| APPLICATION NO. 06AA-00940 | PROJECT NO. 1004991 |
| PROJECT NAME PHASE II INNOVATION | |
| ONE STOP COMMENT FORM LOG | |

DESCRIPTION OF REQUEST ADMINISTRATIVE APPROVAL OF SITE

**AMENDED  
SITE PLAN FOR  
BUILDING PERMIT**

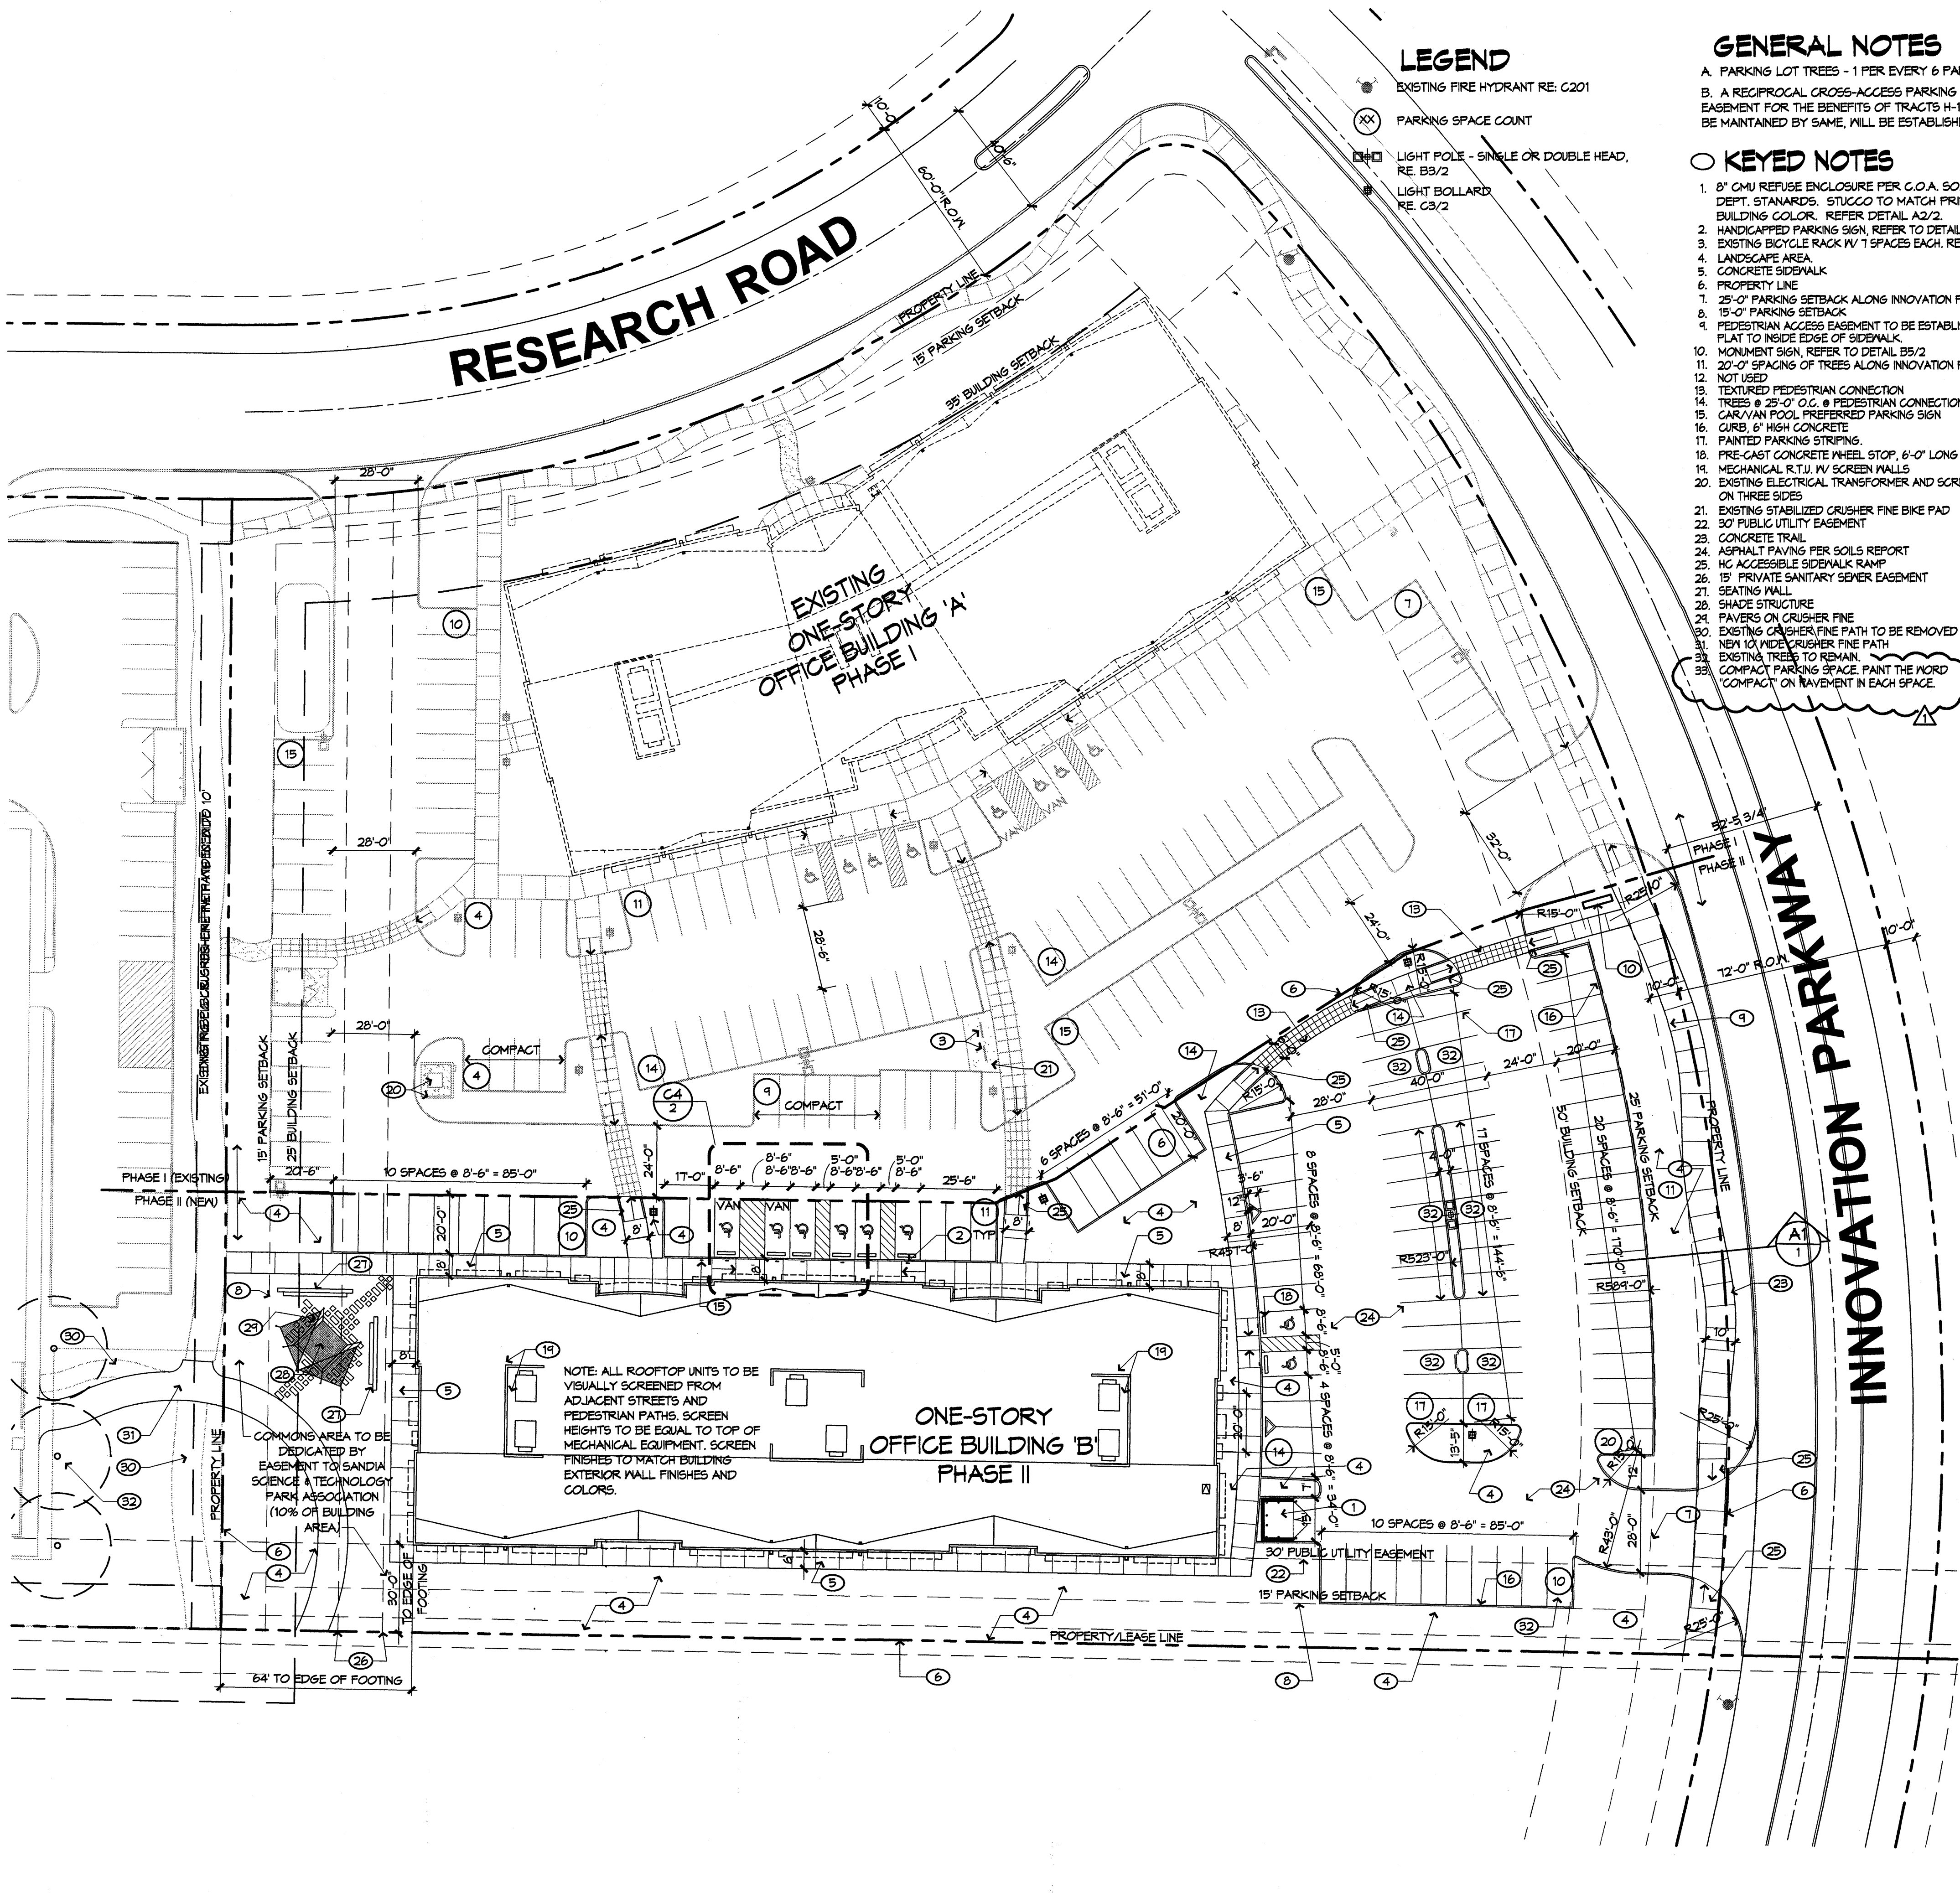
| COMMENTS: <i>(1) ADA SIGN NEW MARKS (2) WHERE IS X-ACCESS (3) WHERE IS SIDEWALK EXTENSION</i> | | | |

| COMMENTS: <i>1. Site plan sheet should be "Site Plan for Building Permit" 2. Remove 6 Creeping Junipers + substitute w/ more creeping Rosemary plants or another shrub</i> | | | |
